# PROPOSED CHANGES APPLICATION REPORT

## Drax Bioenergy with Carbon Capture and Storage

**Document Reference Number: 8.5.1**

**Applicant: Drax Power Limited**

DRAWING NUMBER
 EN010120-PA-LP-8.5.3.9-Sheet1

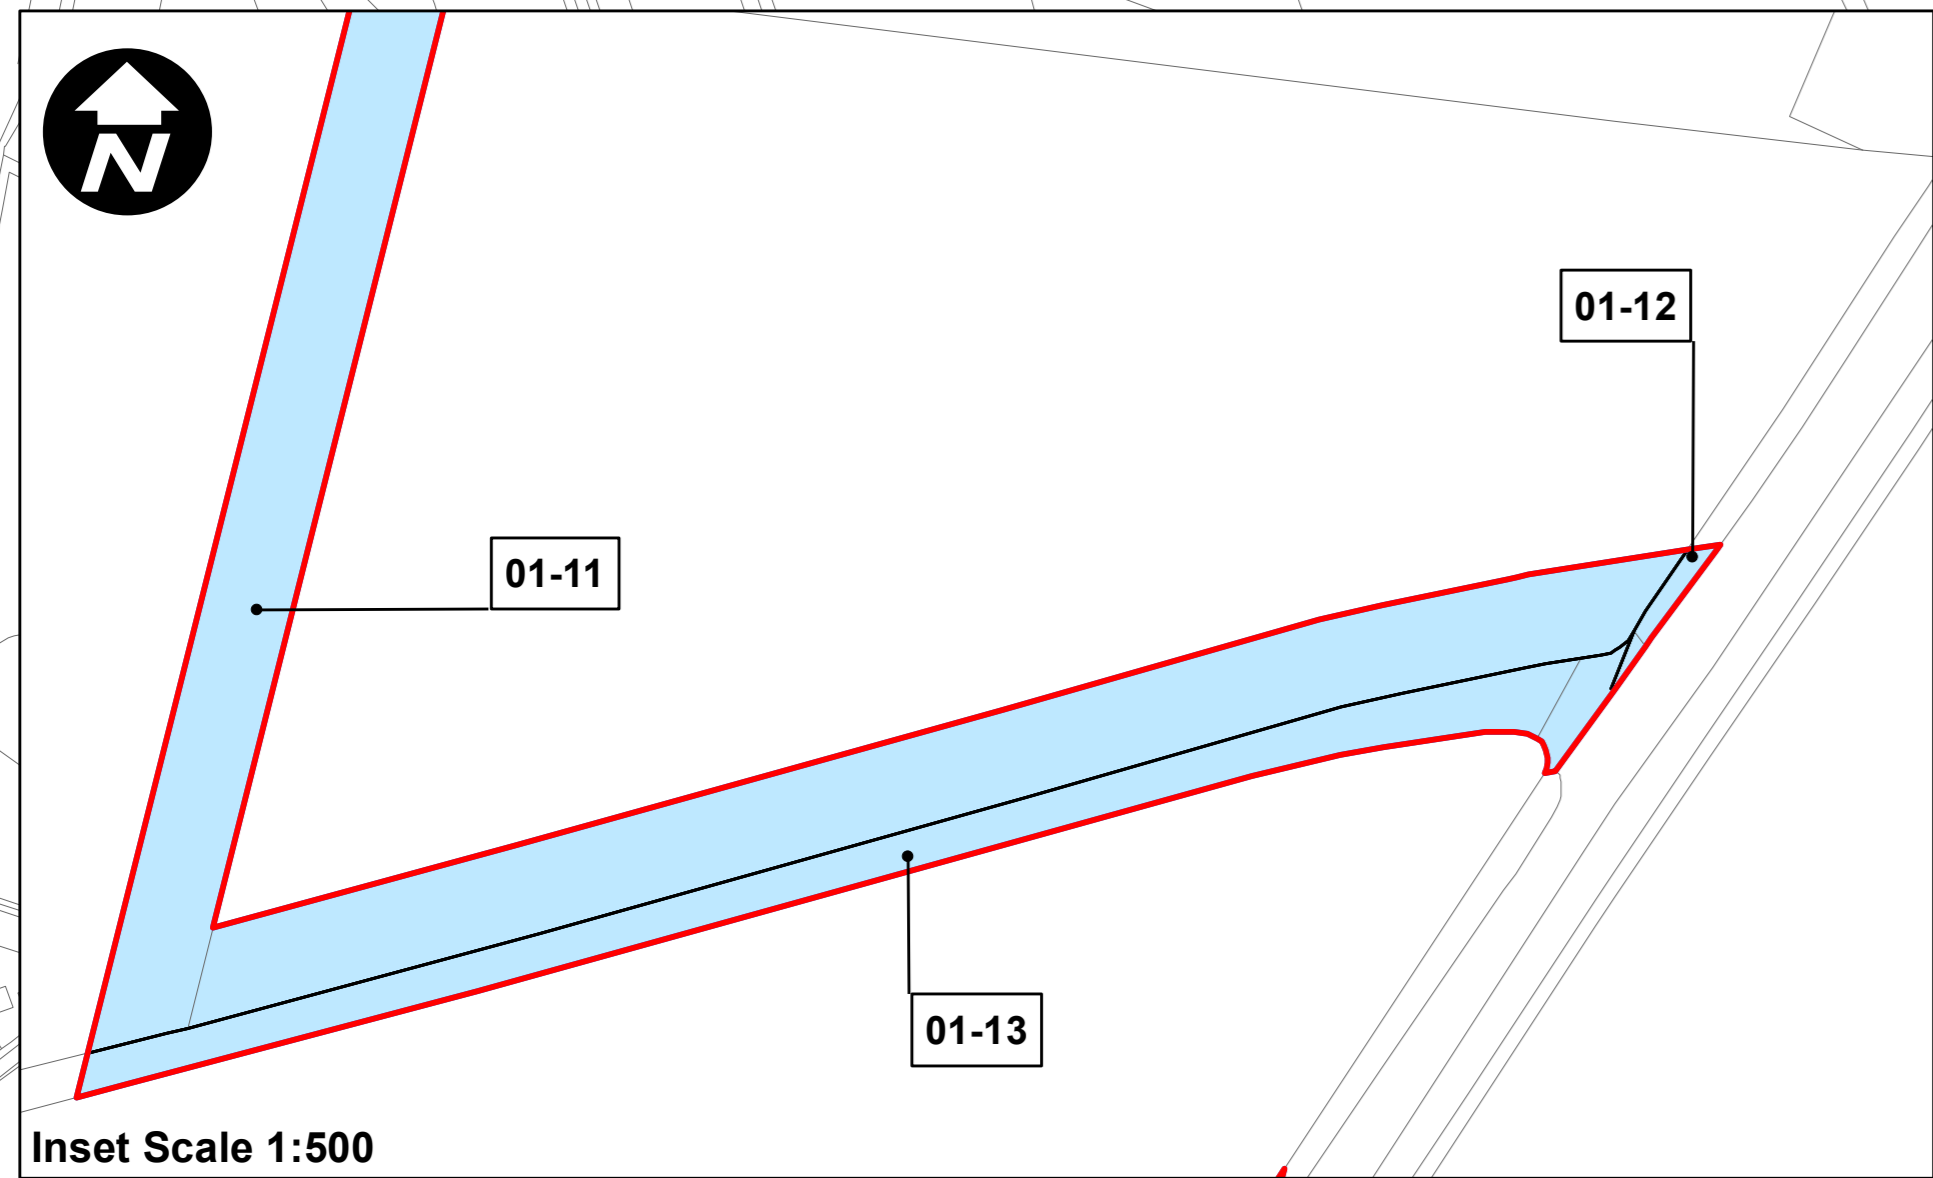
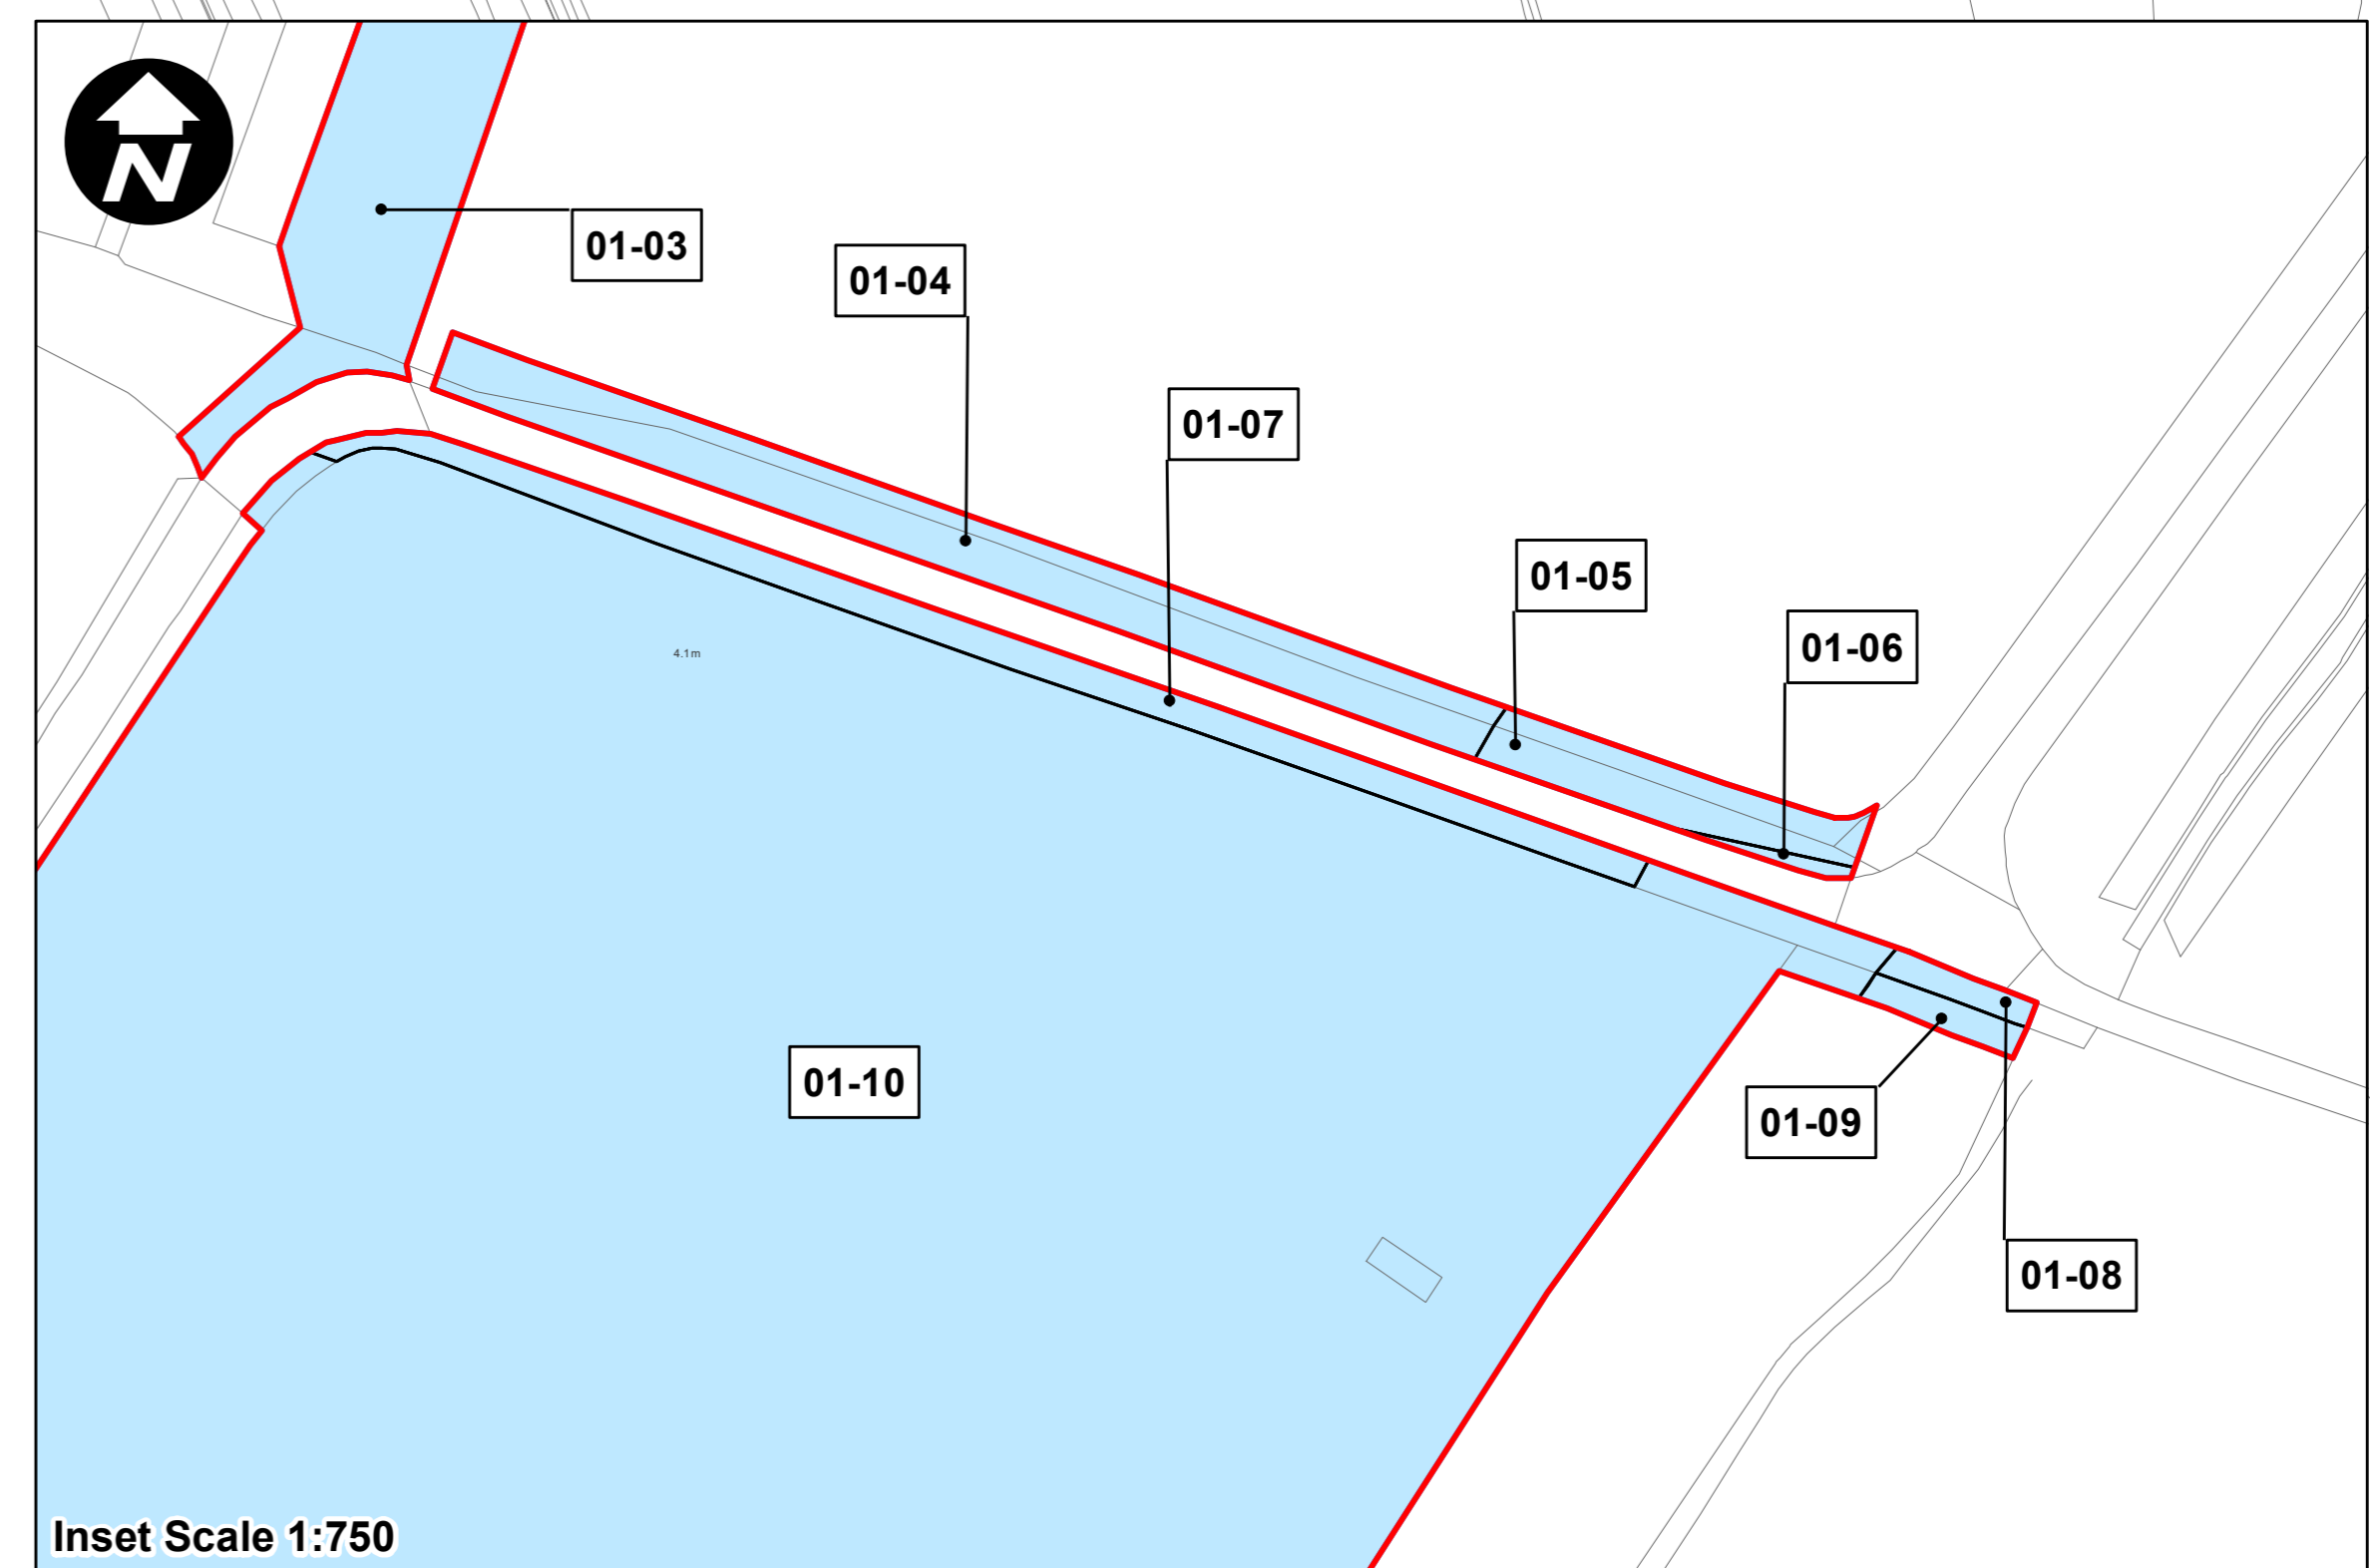
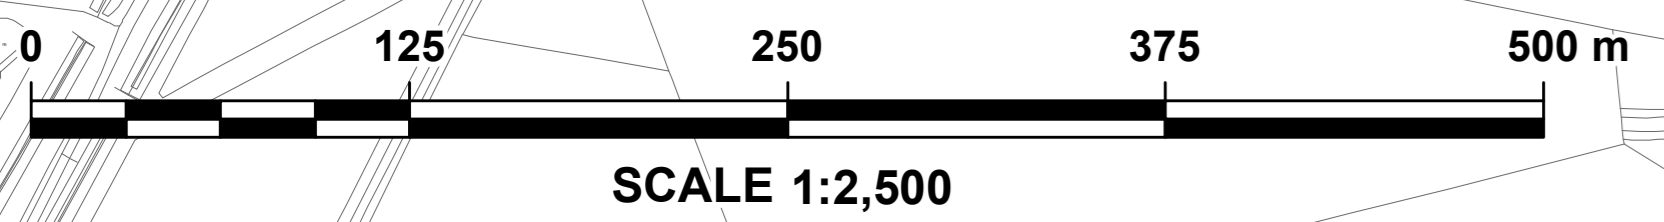
- 1.1.3. The Applicant now proposes two minor changes to the Application which are the subject of this report (the 'Proposed Changes'), details of which are provided below:

- a. Proposed Change 01 ('PC-01'): The Application submitted to the Planning Inspectorate commits to providing floodplain compensation as part of the Proposed Scheme, but did not confirm where this was to be located. Since the Application was submitted, the Applicant has been able to investigate solutions to the floodplain compensation and has continued to engage with Interested Parties, such as the Environment Agency ('EA'), to confirm a suitable solution (see Section 3.2 of this report). The confirmed solution comprises an area of grazed land to the north of the Existing Drax Power Station Site, within the Applicant's ownership, but not previously included within the Order Limits; and

- b. Proposed Change 02 ('PC-02'): Relocation of existing overhead lines in respect of two electrical lines (11kv overhead line crossing the A645 once, owned by Northern Powergrid ('OHL1'), and 11kv overhead line crossing Rawcliffe Road once, owned by Northern Powergrid ('OHL2')) and the Telecommunications line crossing Rawcliffe Road twice, owned by Openreach ('TCL1'), which cross the access route to the Site at A614 (Rawcliffe Road) and the A645, to allow for the delivery of Abnormal Indivisible Loads (AILs) to the Site. This Proposed Change involves land that is outside of the current Order Limits and is not in the ownership of the Applicant.
